CITY OF ALBUQUERQUE

January 11, 2021

**Re: Solare Charter School Phase 2
Traffic Circulation Layout**
Engineer's/Architect's Stamp 11-20-2020 (M19-D031A)

AS101

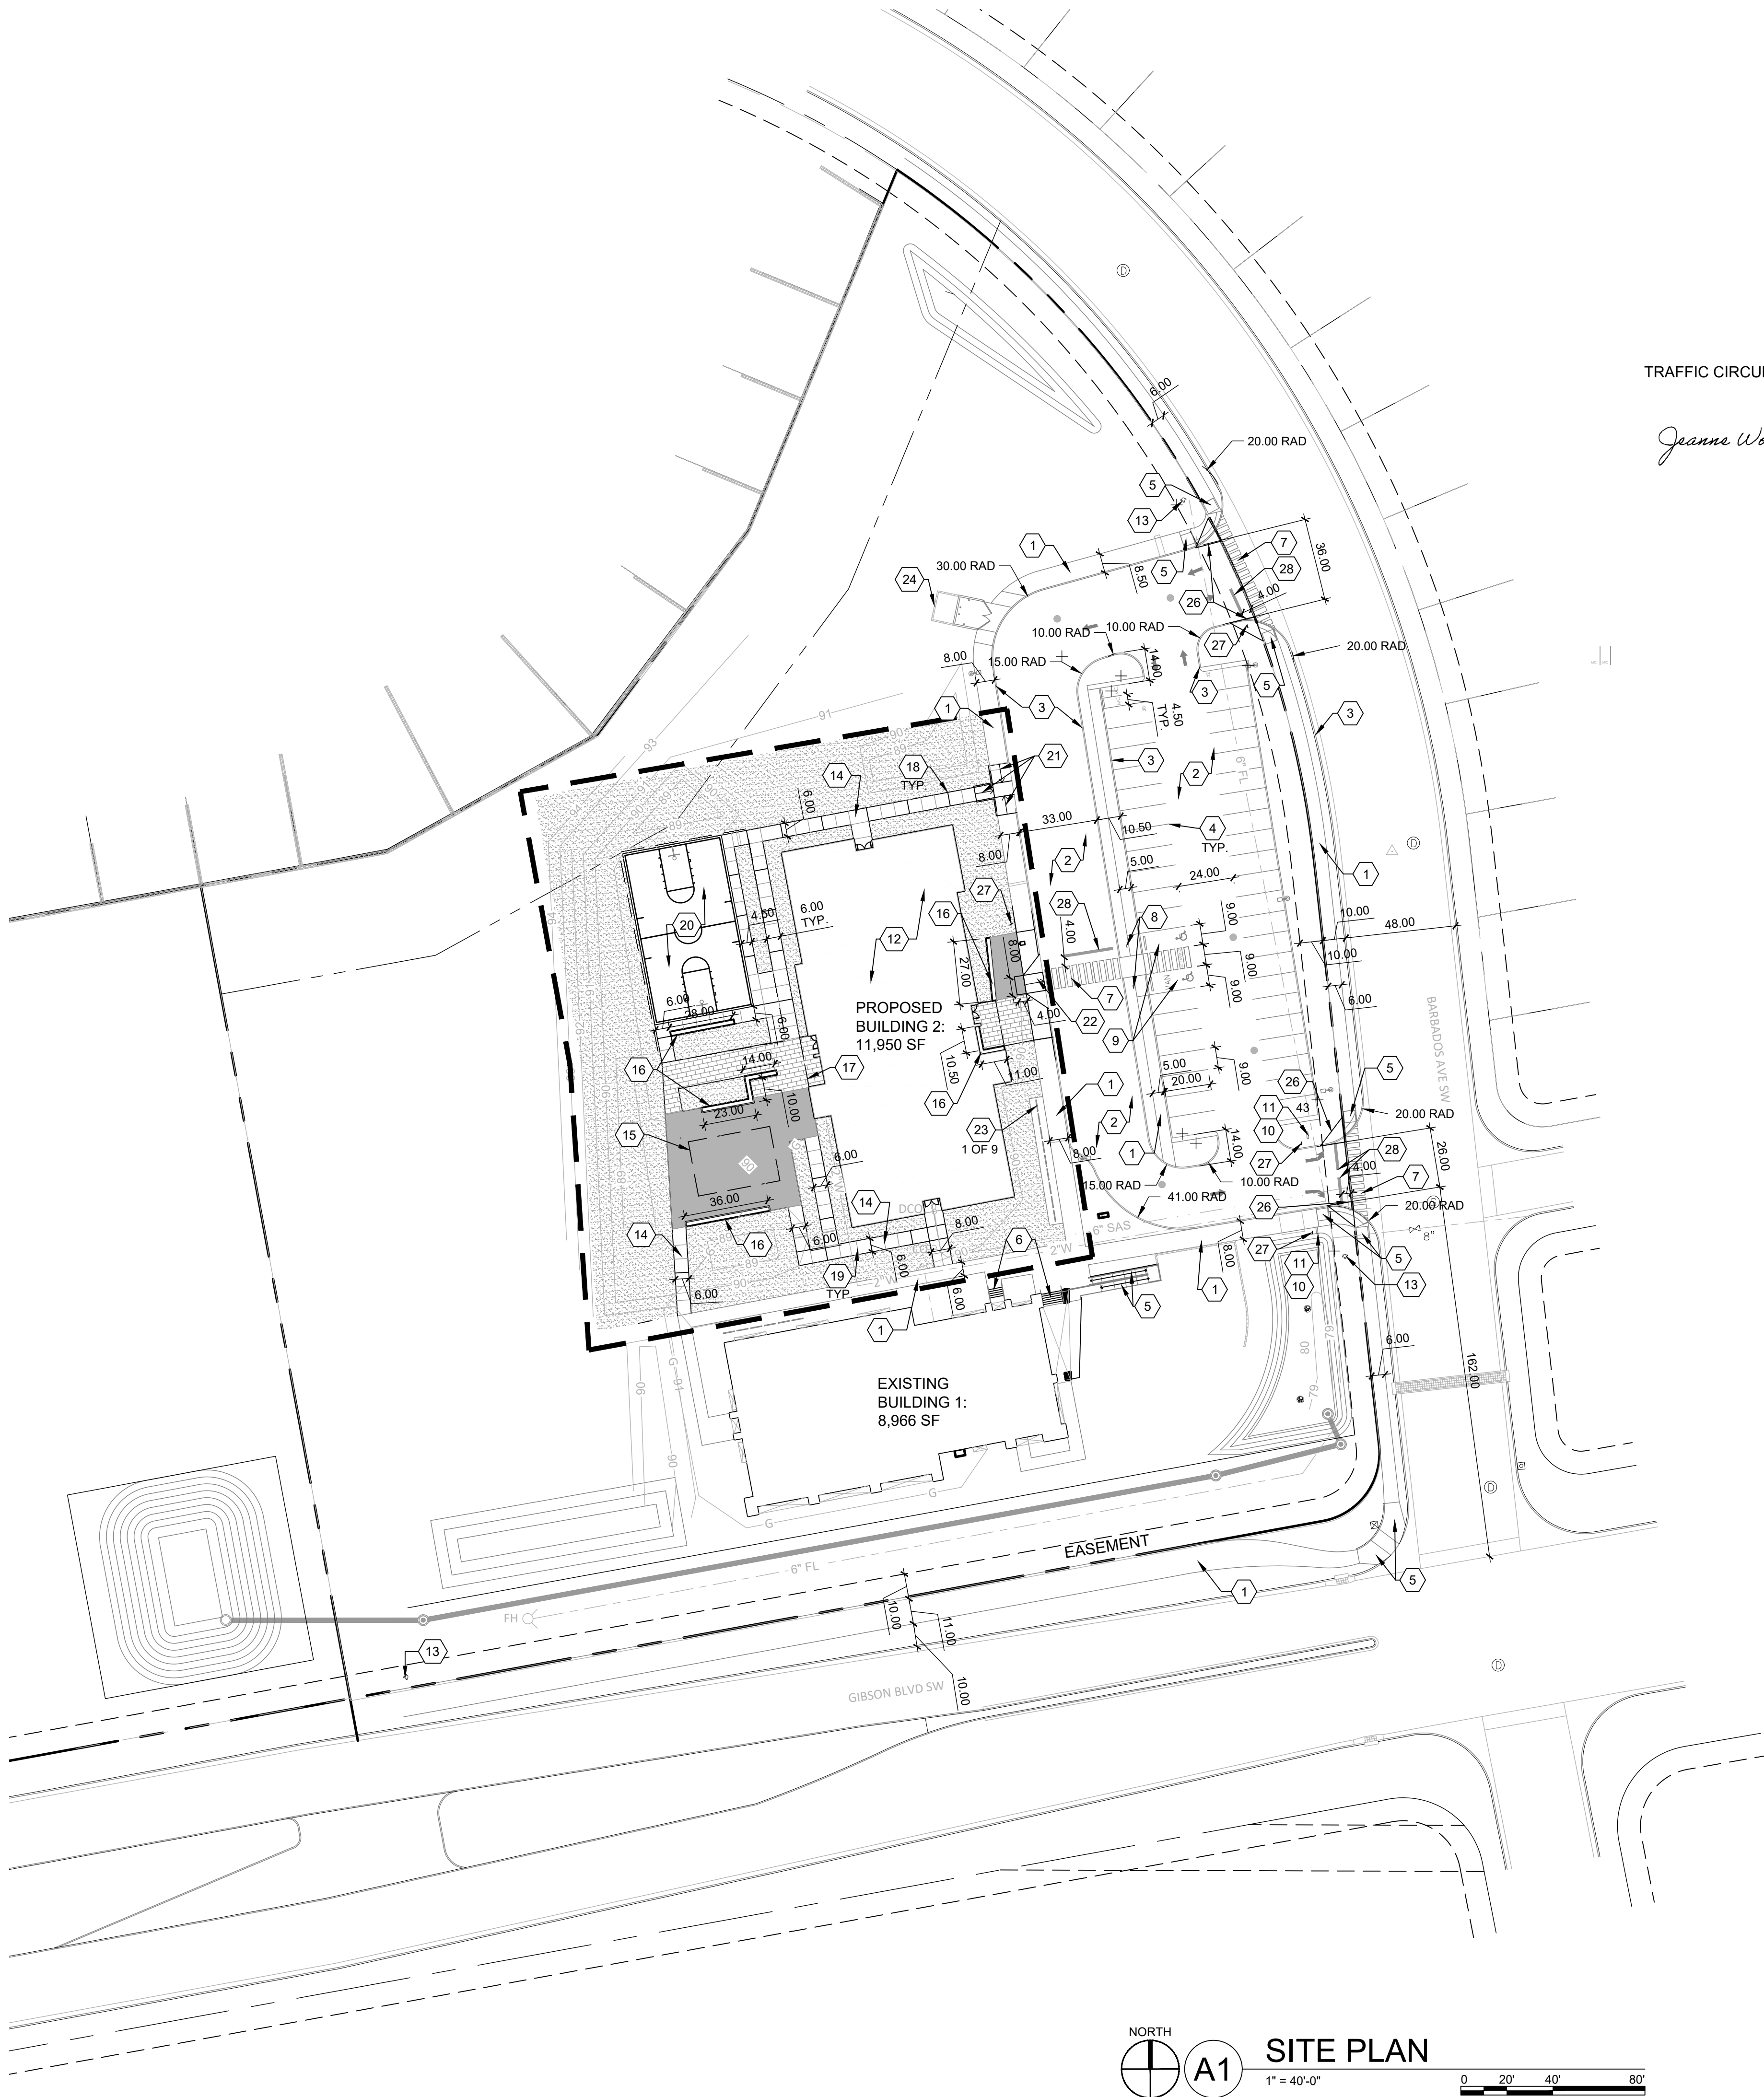
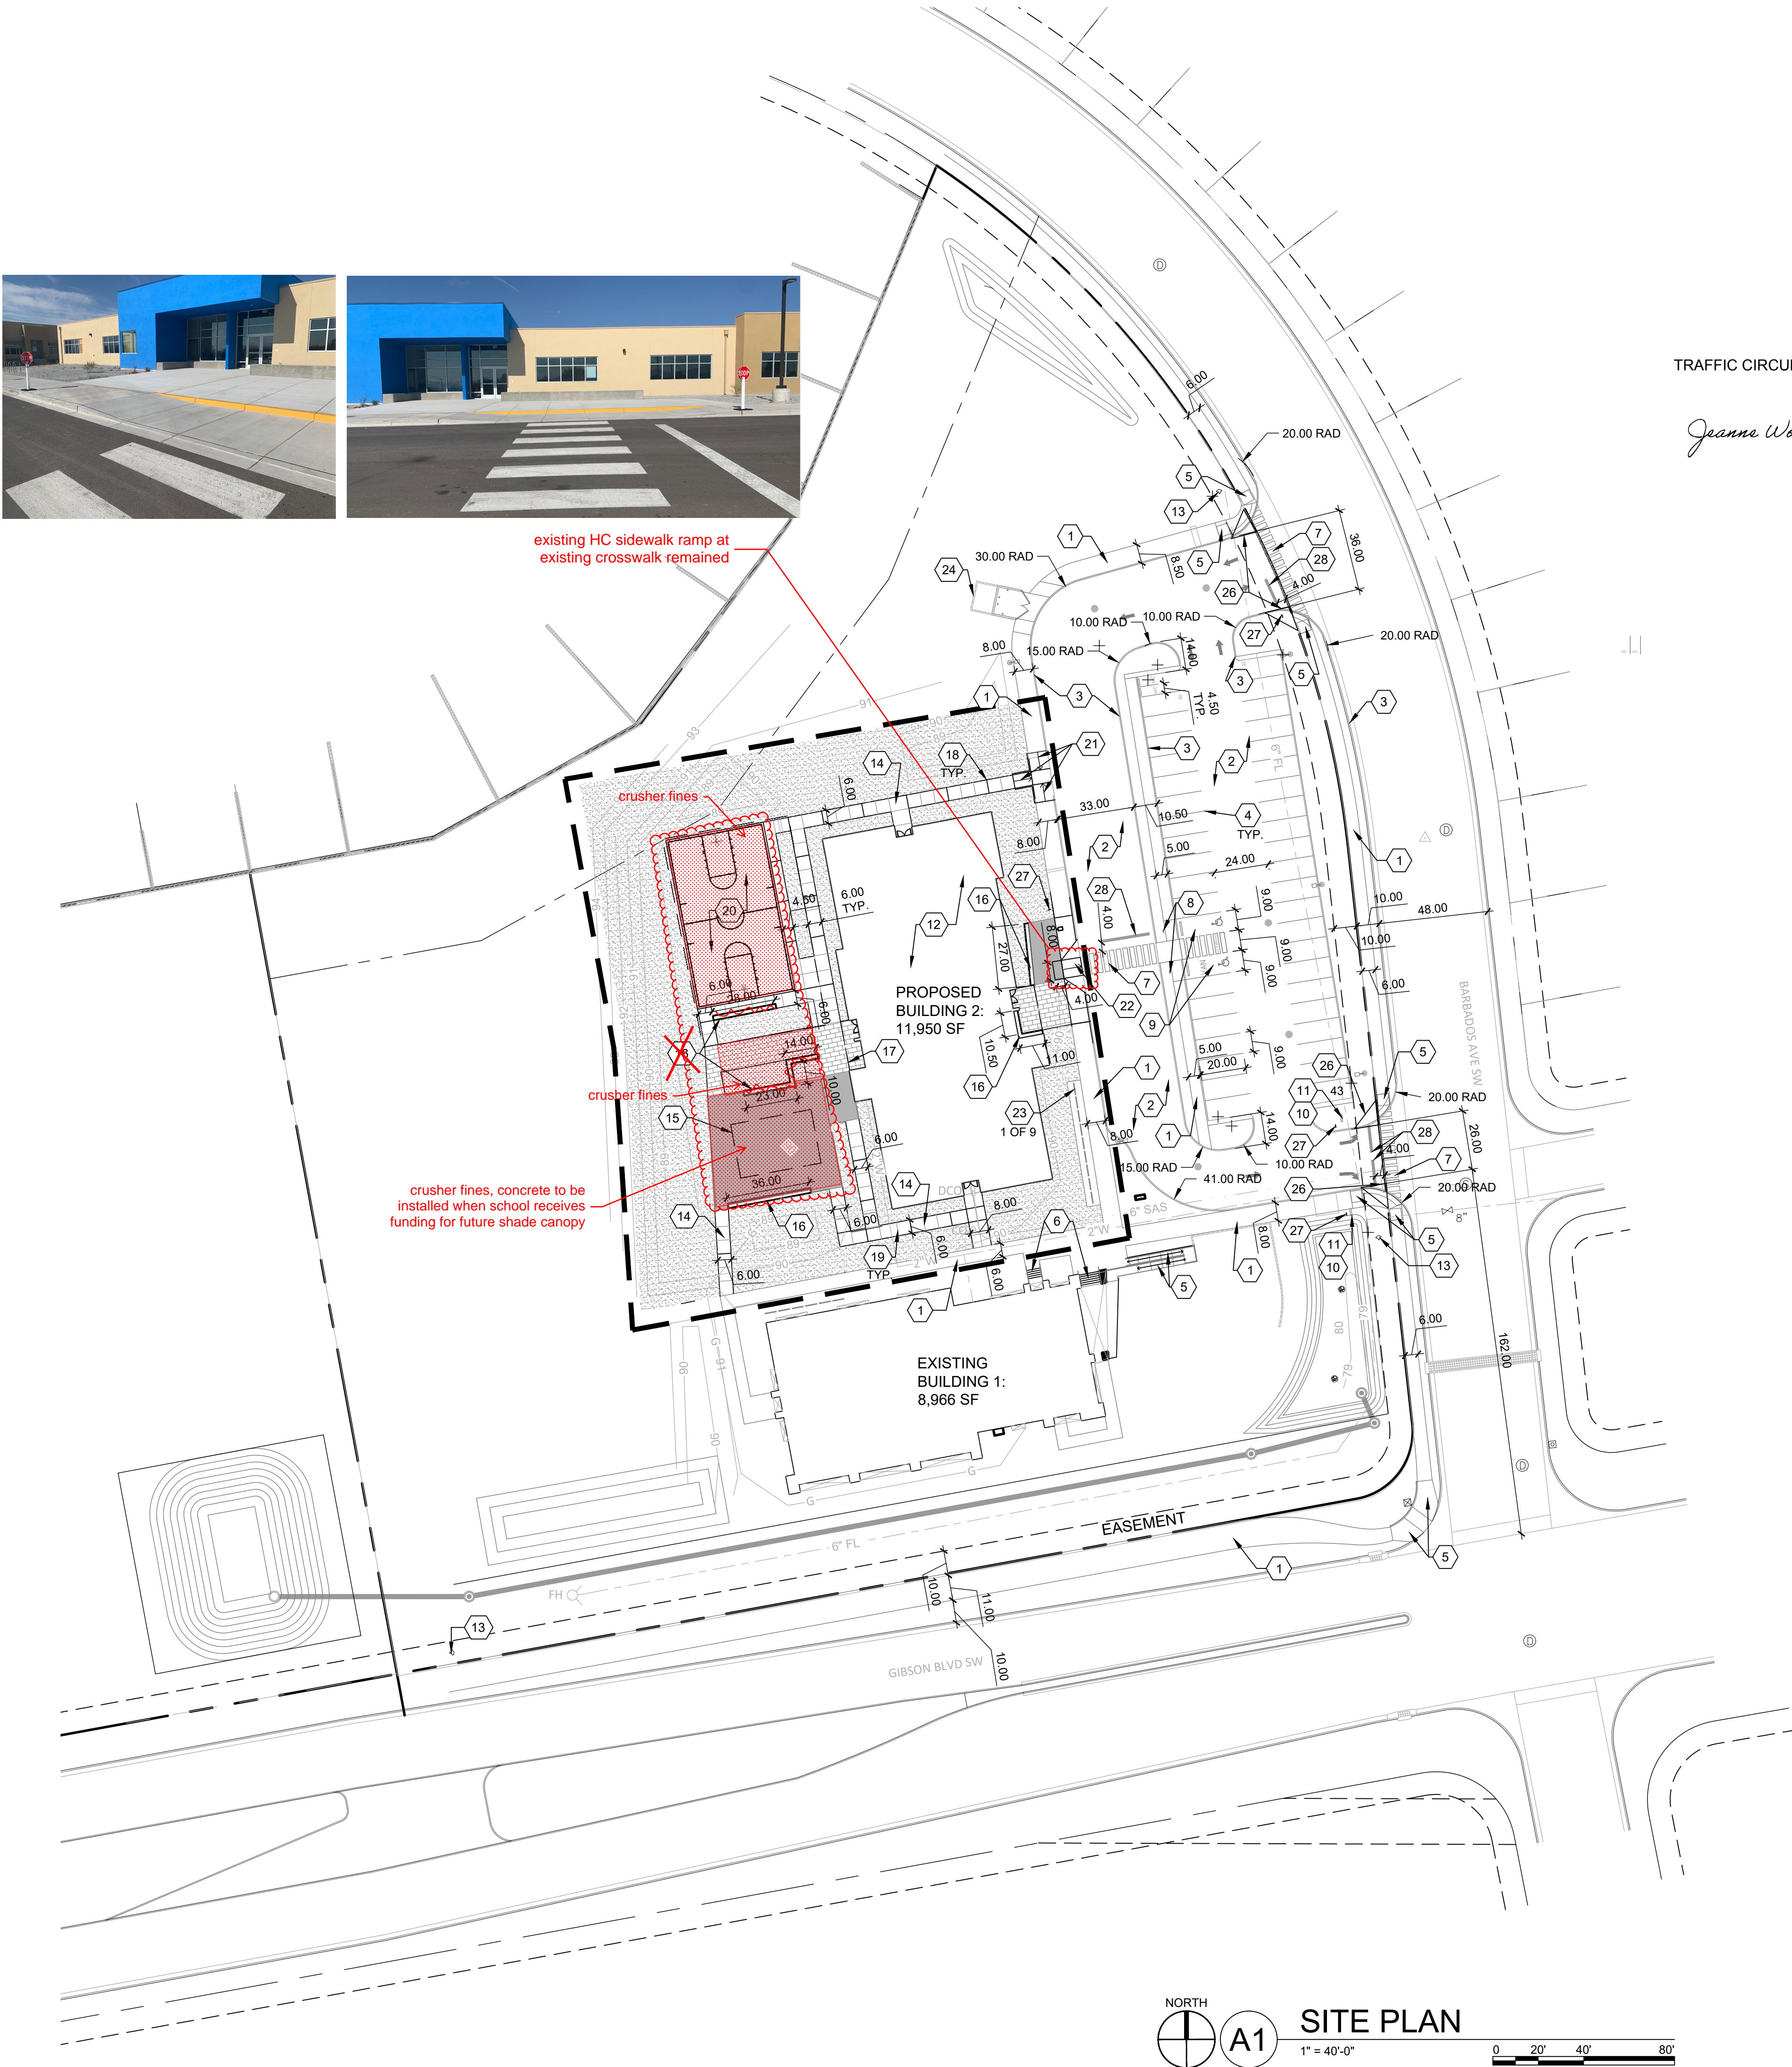
1. Identify the number of students that will now be served by Phases 1 and 2 on the site plan.
2. Provide dimensions for all existing and new sidewalk on the plan.

3. Show maximum 2% cross-slope on the sidewalk detail.
4. Show tie-ins to existing sidewalk to demonstrate a 6-foot pathway to Barbados right-of-way and an ADA pathway to the existing southern building.

5. The new ramp at the west end of the crosswalk will not meet ADA requirements. There will either need to be a minimum 4-foot by 4-foot wide landing at the top with a maximum 2% cross-slope in all directions with a tie in to the sidewalk on either end of the ramp or the ramp detail will need to be modified to provide ramps that are parallel to the curb in lieu of one with flares.

6. Include the following general notes from the Neighborhood Impact Assessment recommendations:
 - Solare Charter School shall have a staff member present during drop-off and pick-up times to help students safely cross the drive aisle when double stacking is implemented within the drive aisle.

- Staff at Solare Charter School should get familiarized with the EPA Idle-Free Schools Tool-Kit to minimize any idling of vehicles.
7. In accordance with the recommendations in the Neighborhood Impact Assessment, prepare work order plans to include crosswalks at drive entrances.
